Online Comment

Application	H09-0475-18
Location	Penny Hill Road Holbeach Spalding
Proposal	Erection of 32 dwellings with associated garaging, roads and sewers

Name	Gine Chapman
Address	Environmental Services South Holland District Council

Date Submitted	14-06-18
For/Against	Comments

TITLE LOCATION PLAN

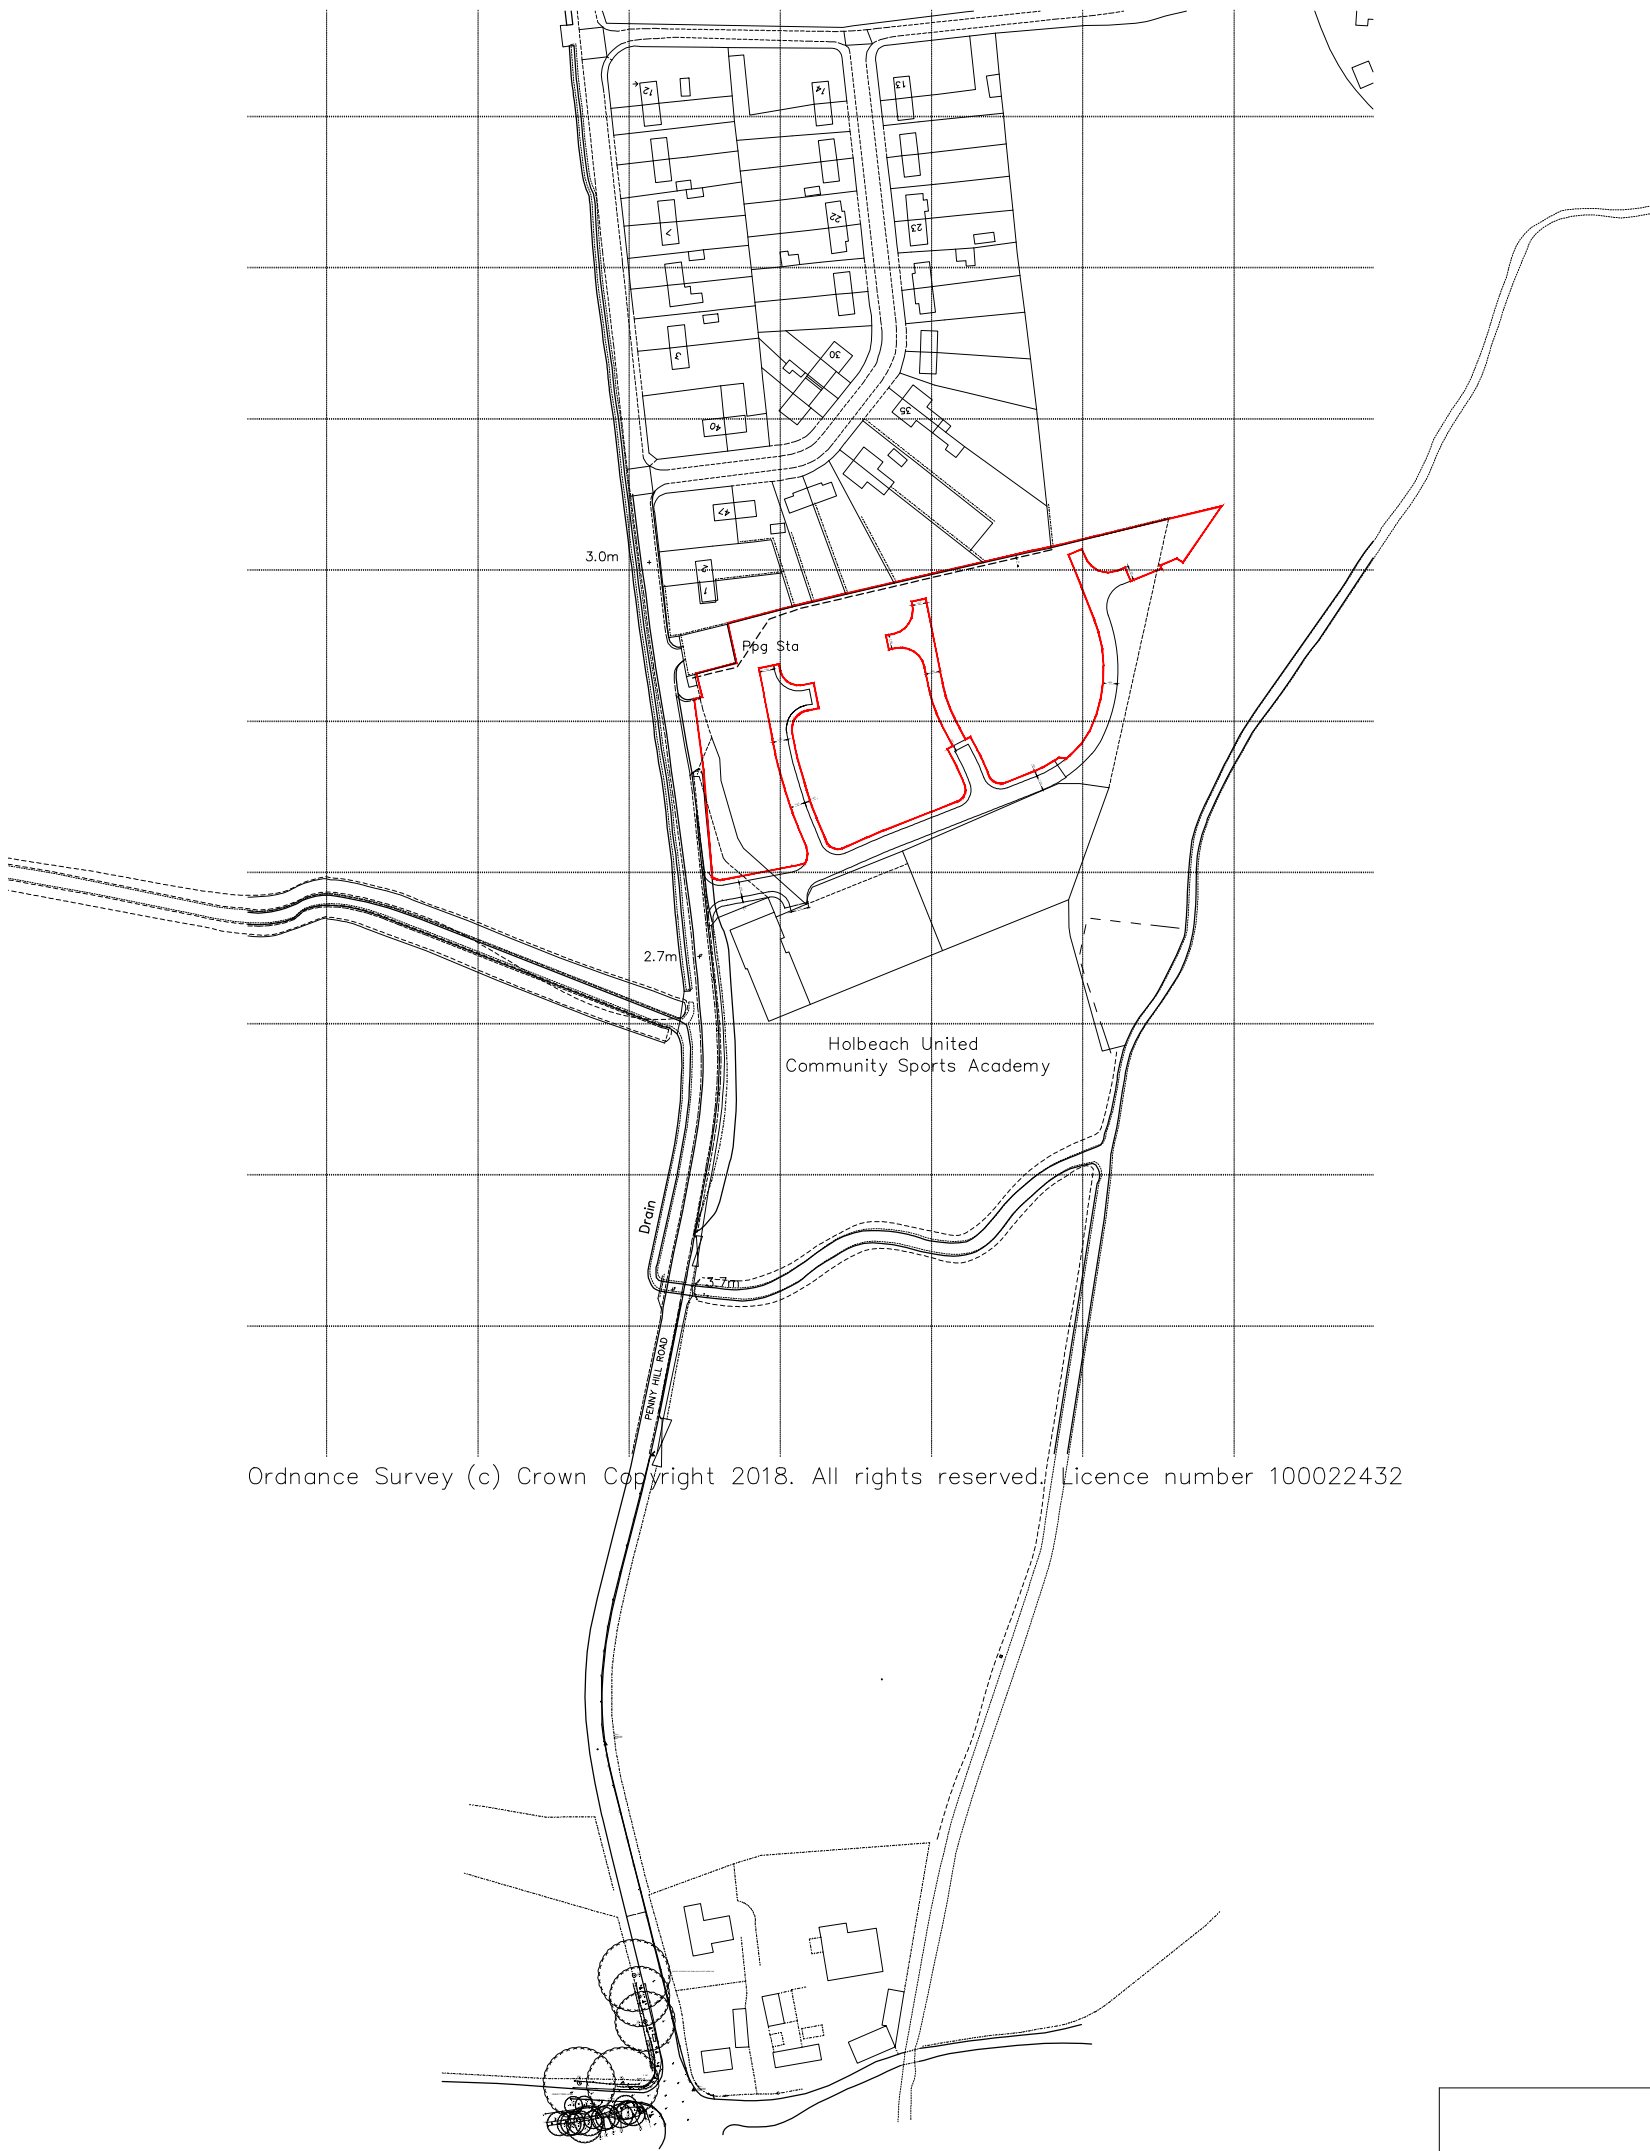
Access roadways to all residential properties should be constructed to an adoptable standard under an agreement with Lincolnshire County Council so that they will become public highways. This will enable refuse/recycling collections to be carried out from outside individual properties without the need for communal collection points at the point where private driveways adjoin public highways.

If not utilised correctly communal collection points become areas of dispute for residents of adjacent properties.

Should it be agreed that communal collection points will form part of this development the position of those collection points should be made clear to the potential occupiers of the properties nearby. This should not just be to the properties that will need to use the collection points (plots 19-25inc and 28-32inc) but also the ones who will have them outside their properties (plots 18, 26 and 27).
